## Norwest Private Hospital – New Level 4 Consulting Rooms

### RESPONSE TO SUBMISSIONS

Block/ Zone
A, B AND D
 Drawing Title
**EXTERNAL ELEVATIONS
 SECTIONS
 MEDICAL SUITE EXPANSION**

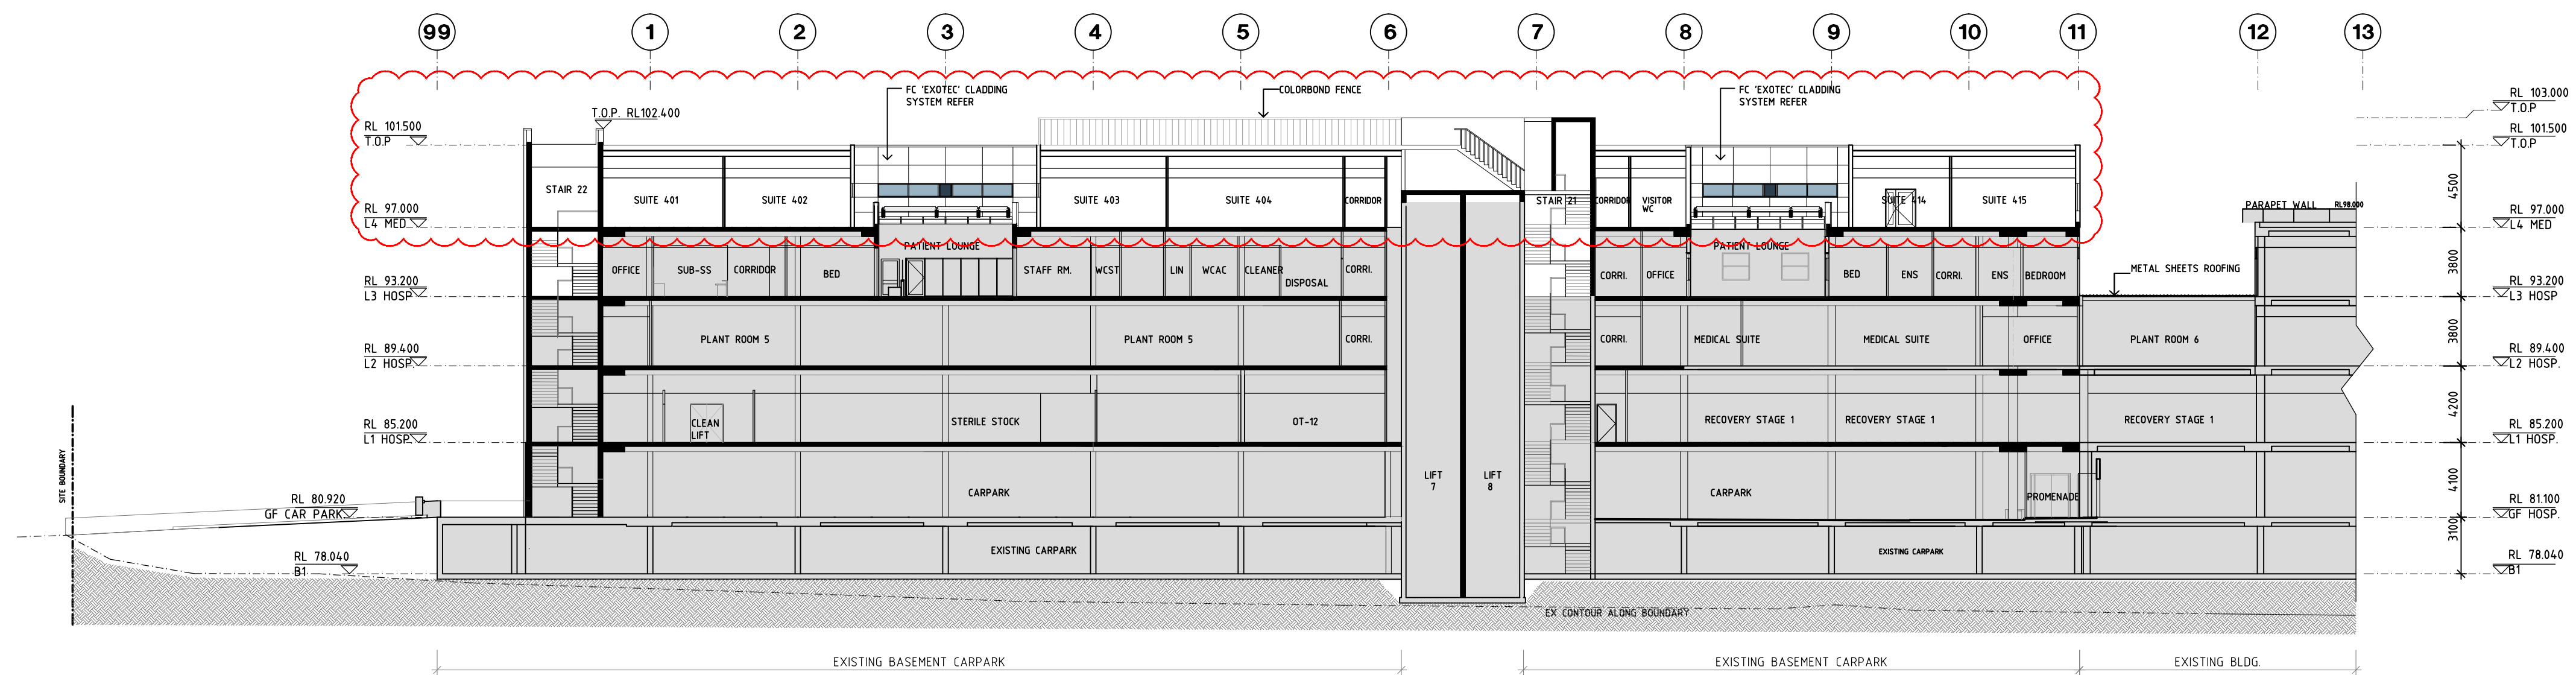
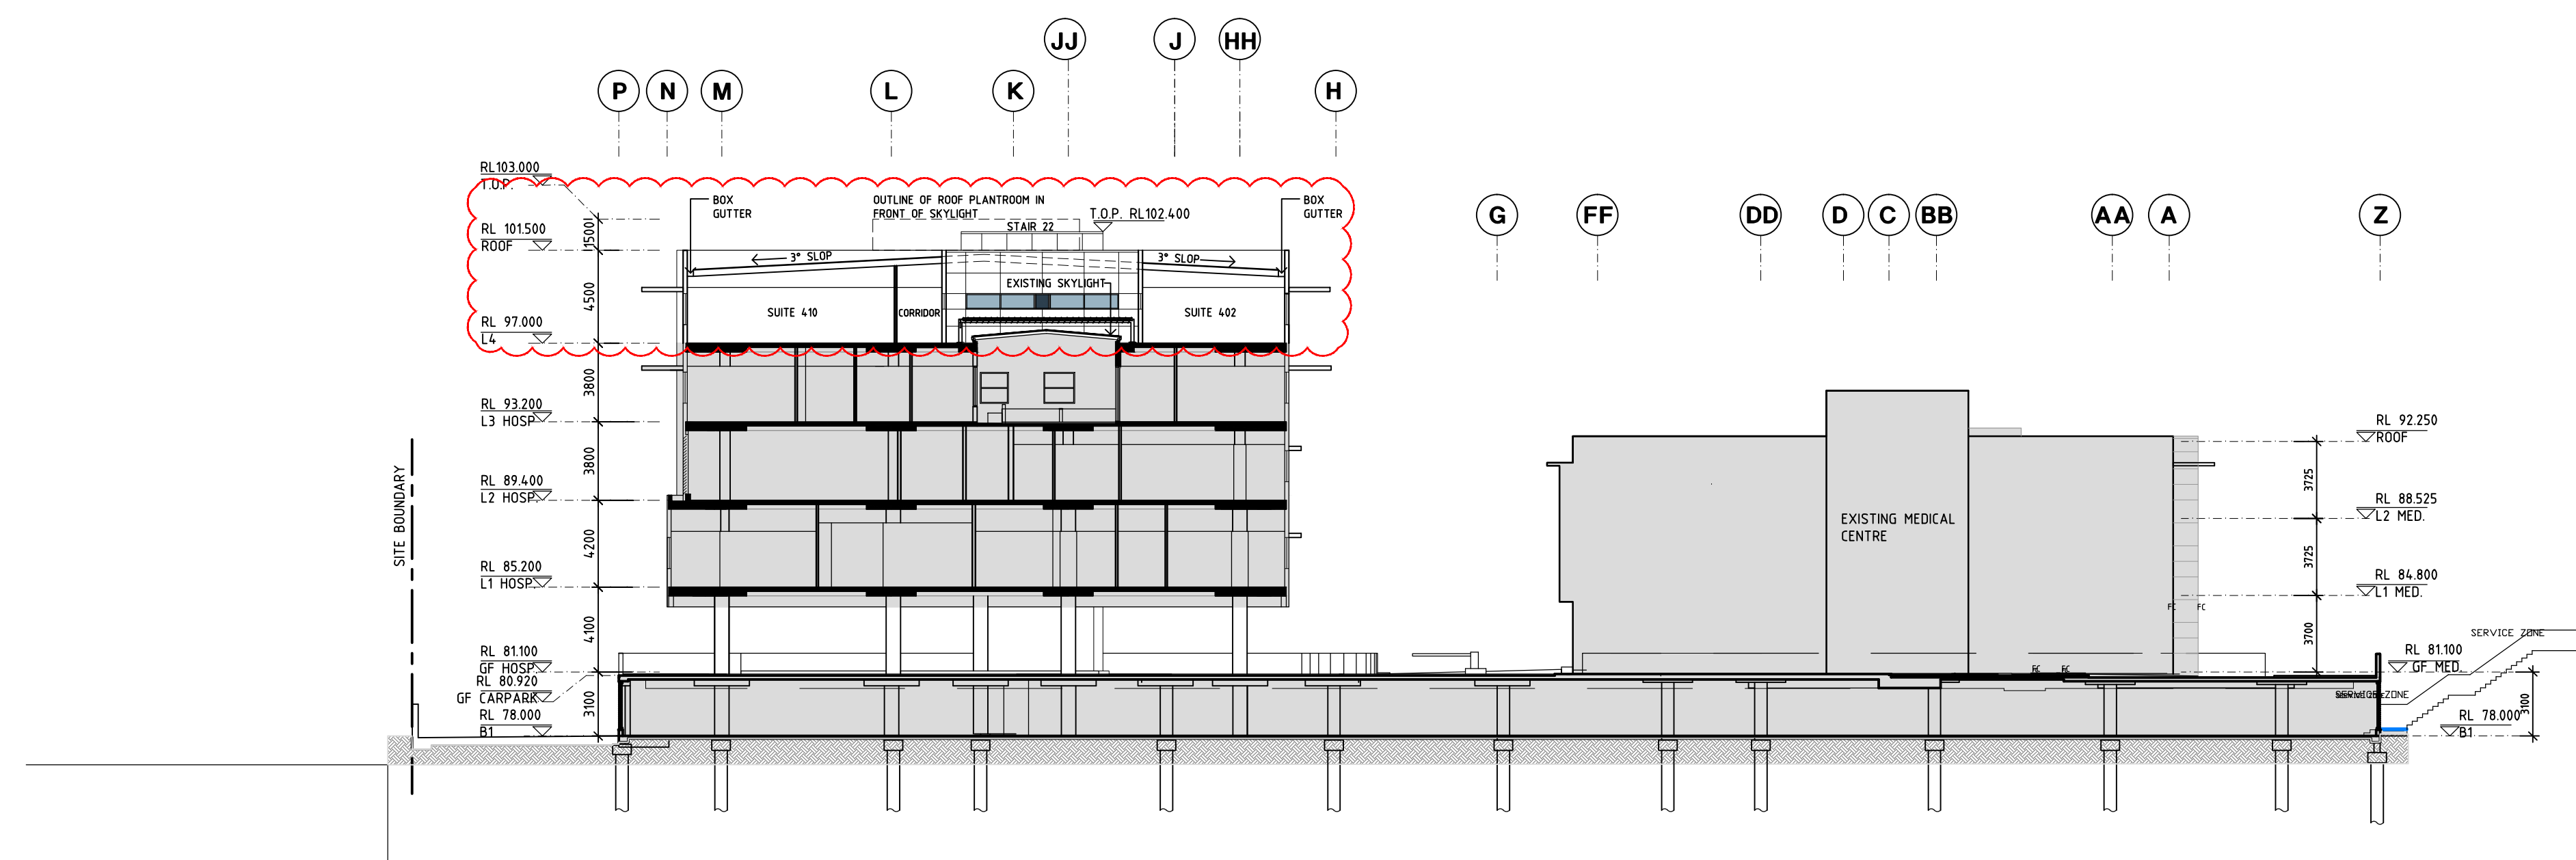
5	Additional parking spaces are proposed along the southern boundary. The fill/wall required to sustain the new parking area is located adjacent a significant drop off with the neighbouring property. More detailed plans should be provided to identify the level changes and impact on the adjoining lot.	Design detail will be the same as that recently completed for the New Wing building – see photo below.
